Arun District Council
Arun Civic Centre
Maltravers Road
Littlehampton
West Sussex BN17 5LF
Planning & Building Control General Enquiries
Tel: (01903) 737756 Fax: (01903) 730442
Dx: 57406 Littlehampton
Minicom: 01903 732765
e-mail: planning@arun.gov.uk
website: www.arun.gov.uk/planning

Application No: P/159/21/PL
Site Address: 253-255 Inglenook Hotel Pagham Road Pagham PO21 3QB
Description of works: Variation and removal of conditions imposed under P/58/19/PL for the variation of condition 2-plans condition & 16-external lighting of roads & footpaths & removal of conditions 11-footpath access through Hotel site & 13-signage of vehicular access previously proposed.

Thank you for your internet representation made on 22nd December 2021 which has been recorded as an objection with the comments as follows:

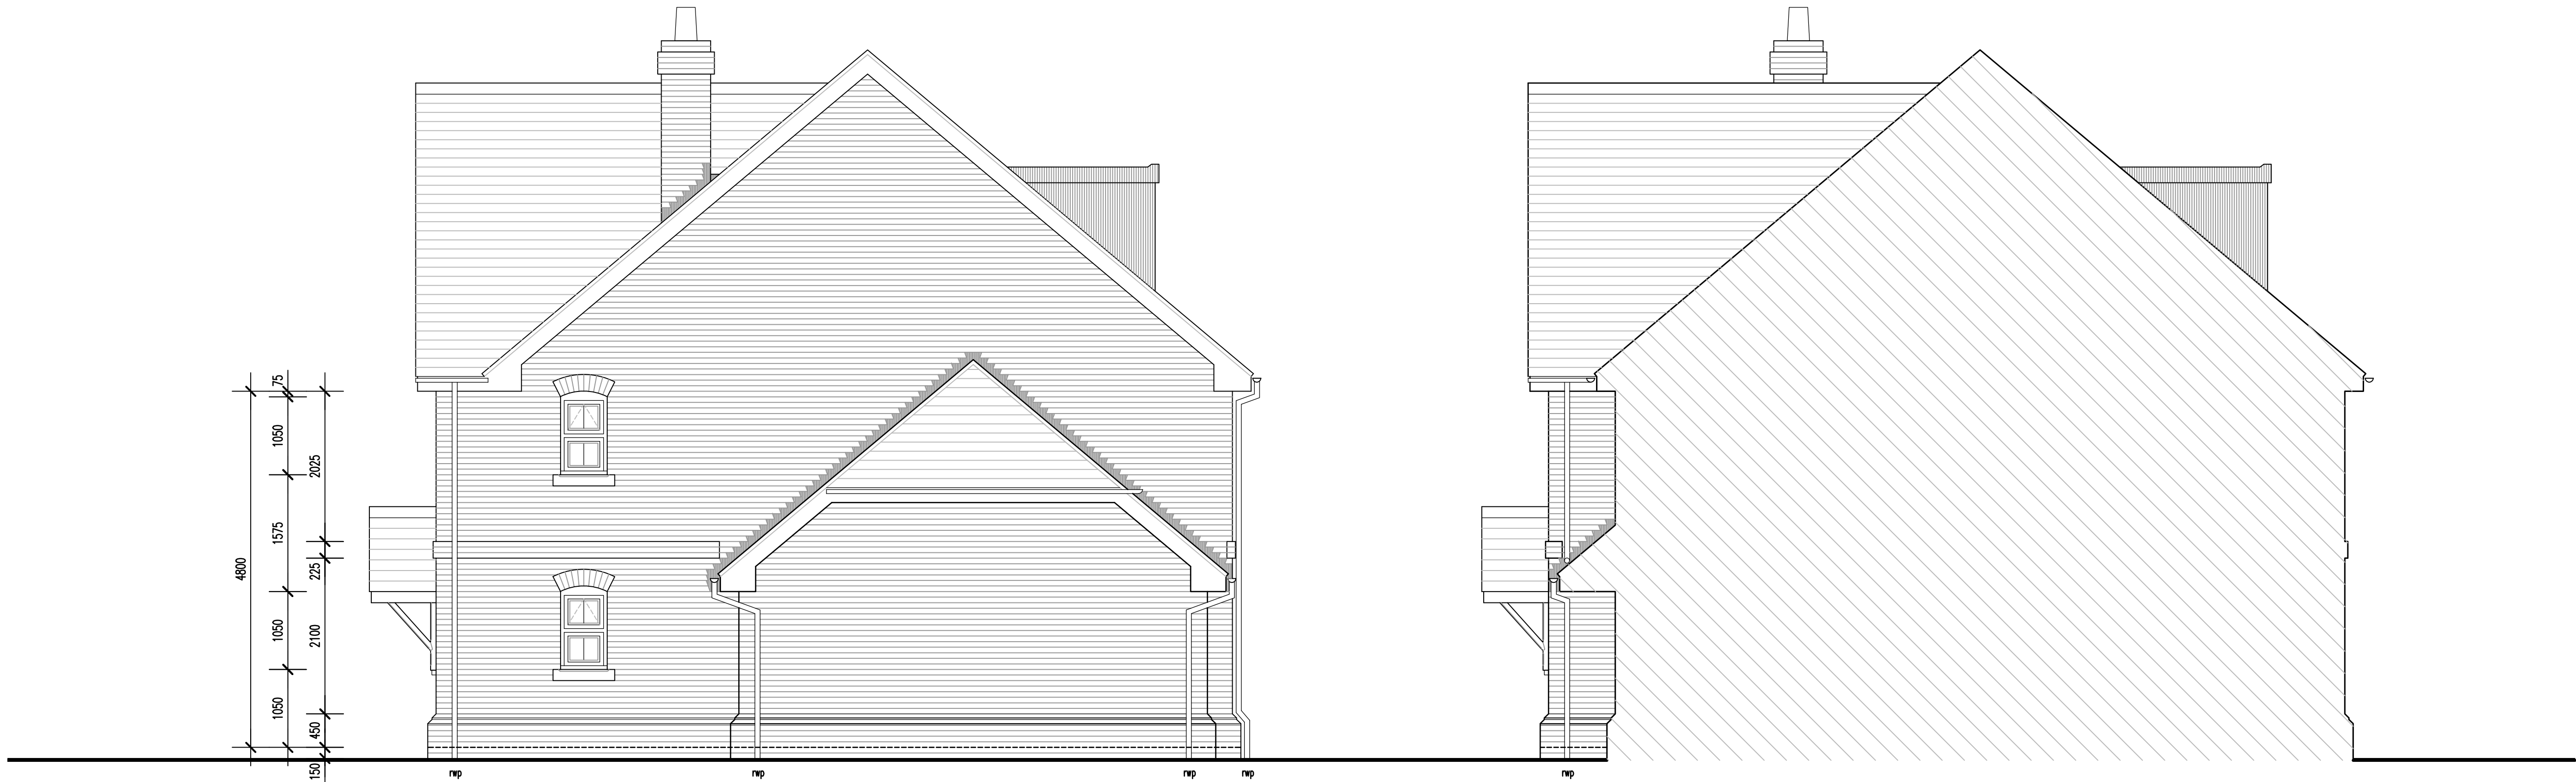
On application for the revised houses why have they installed dormer windows instead of rooflights, due to the proximity of neighbours which will remove privacy.

The roofs have already been installed on plots 8 & 9 and are vast, however planning permission has not yet been granted for the proposed plans?

Refuse Vehicle Swept Path Analysis & Bin Collection Distances

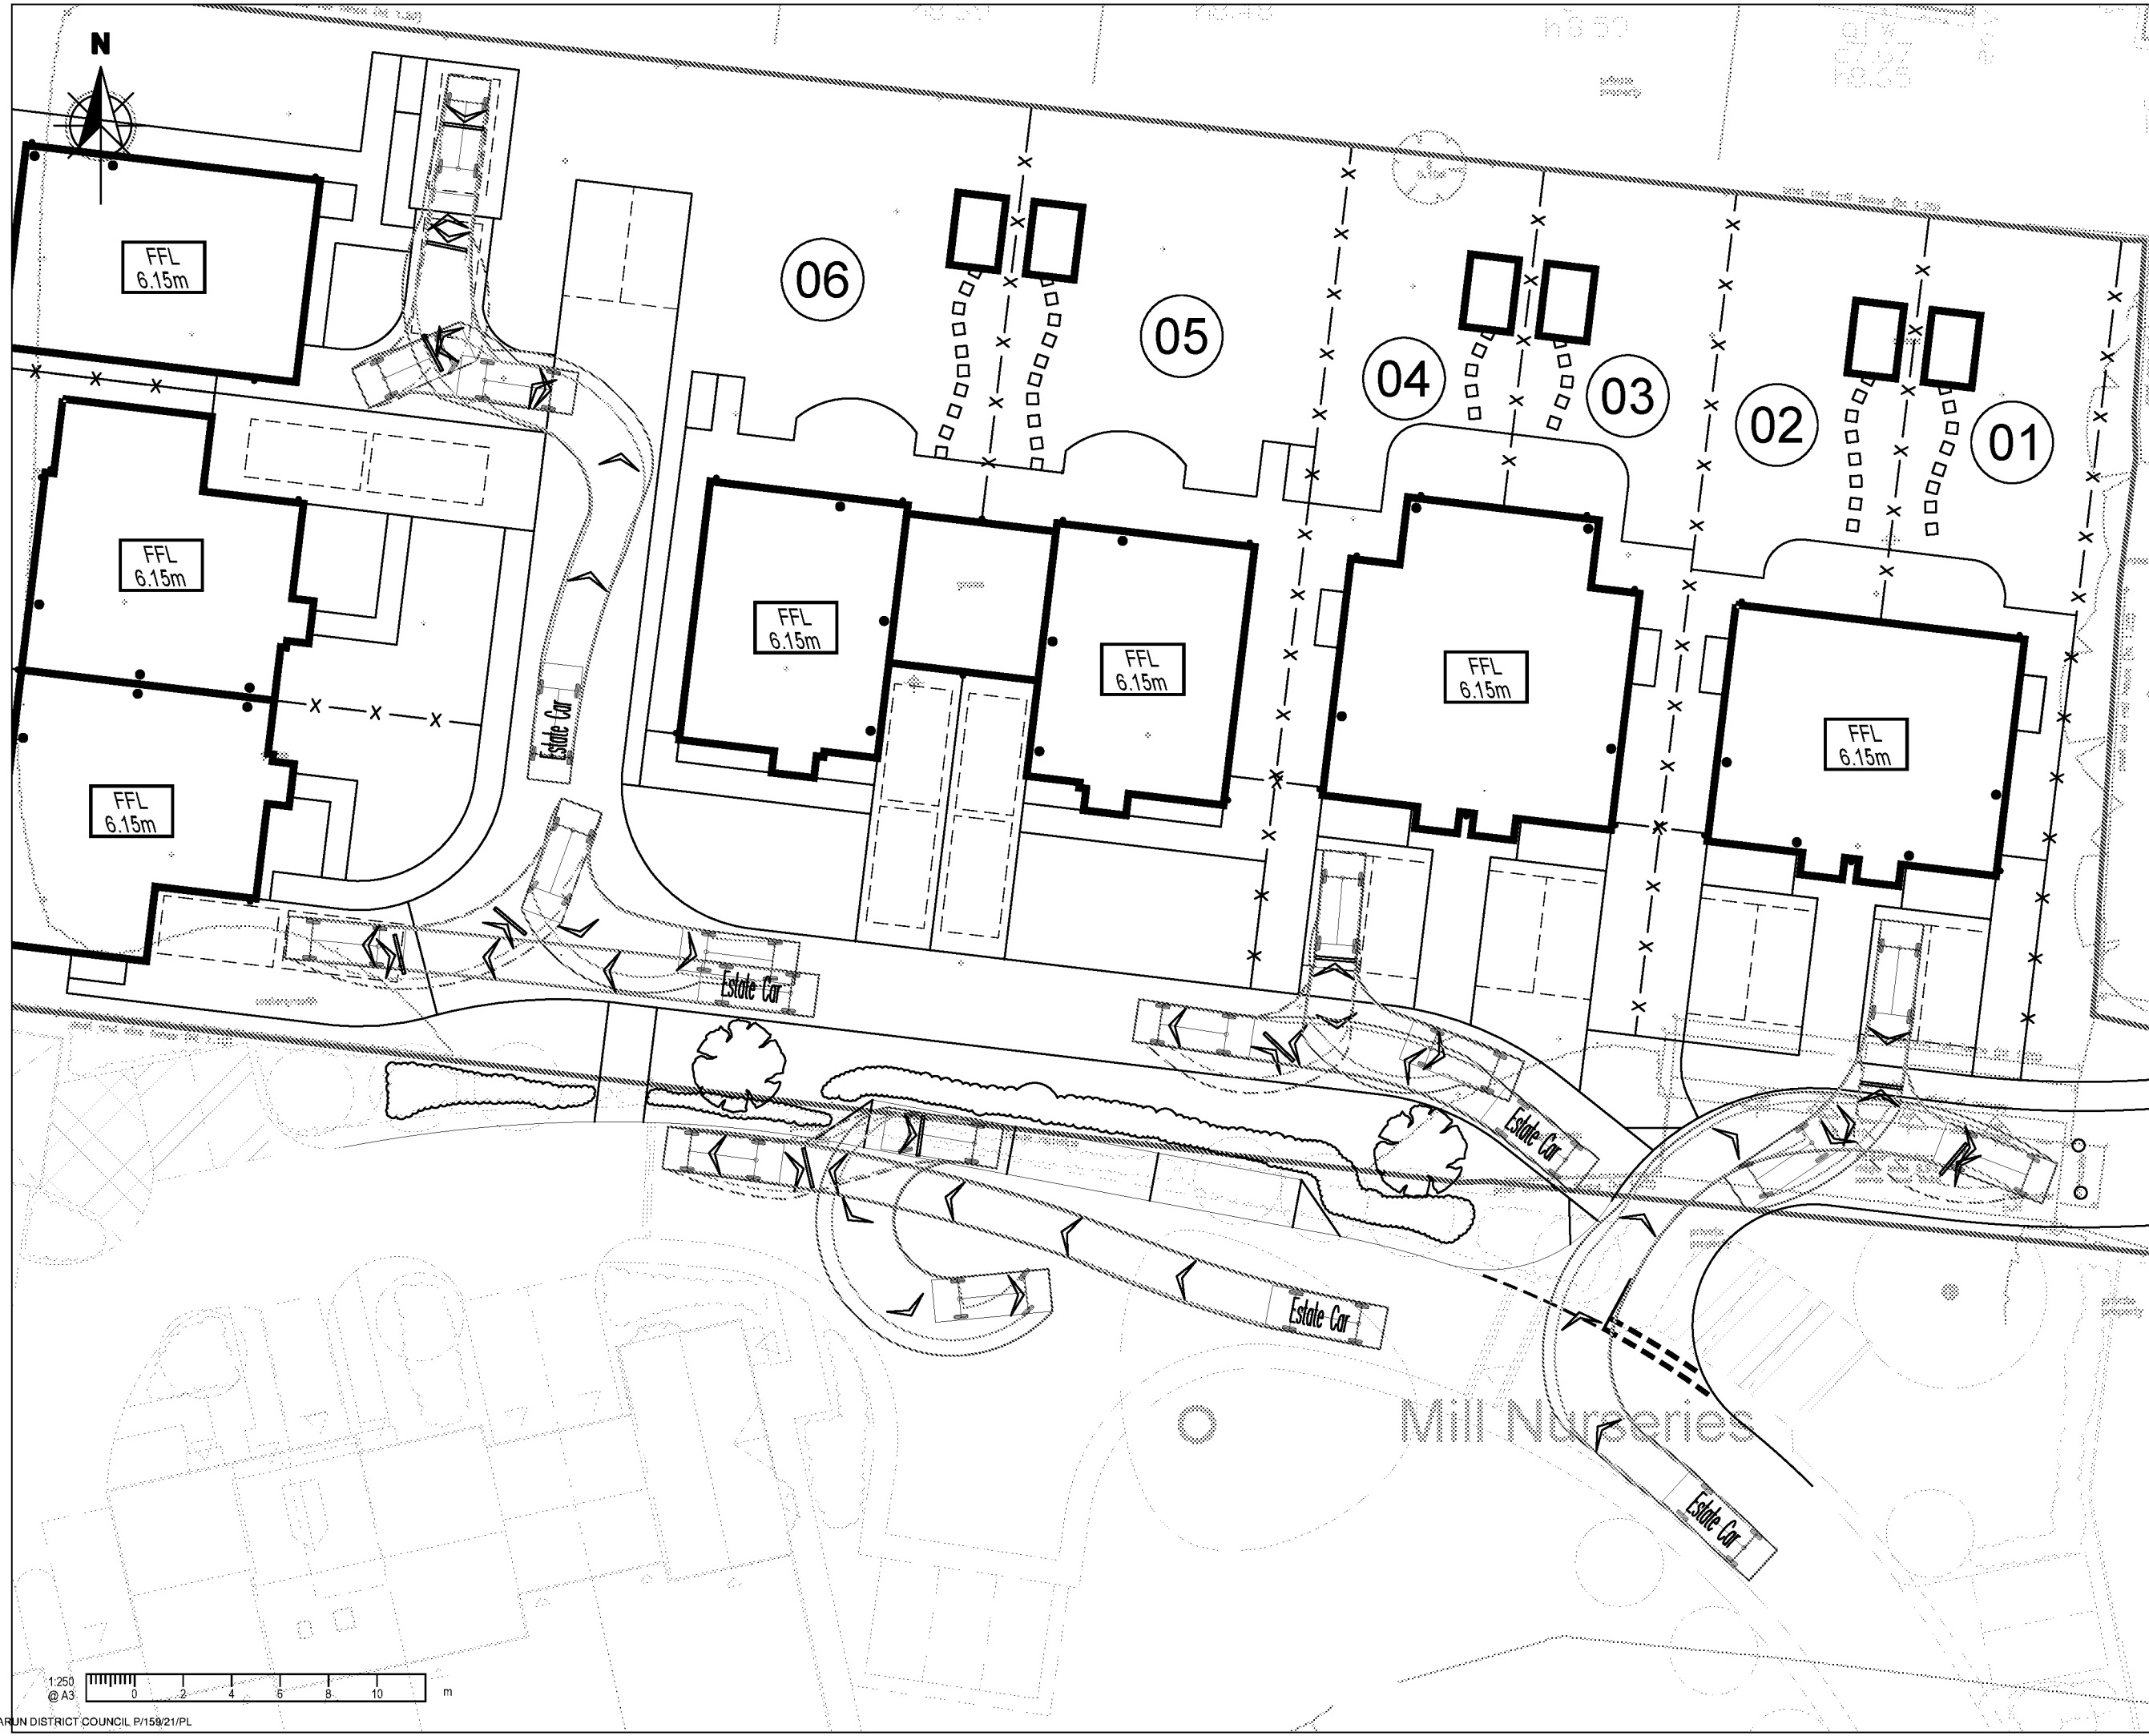
Turning circle is not big enough as overhang of the Fire Tender swings over plot 6 land this is because plot 9 now have an additional parking space outside their garage.

If plot 6 places hedges around its perimeter what happens?
This is not a big enough turning circle and not fit for purpose.

If this parking space is removed from plot 9 this wouldn't be suitable for a 4-bedroom house.
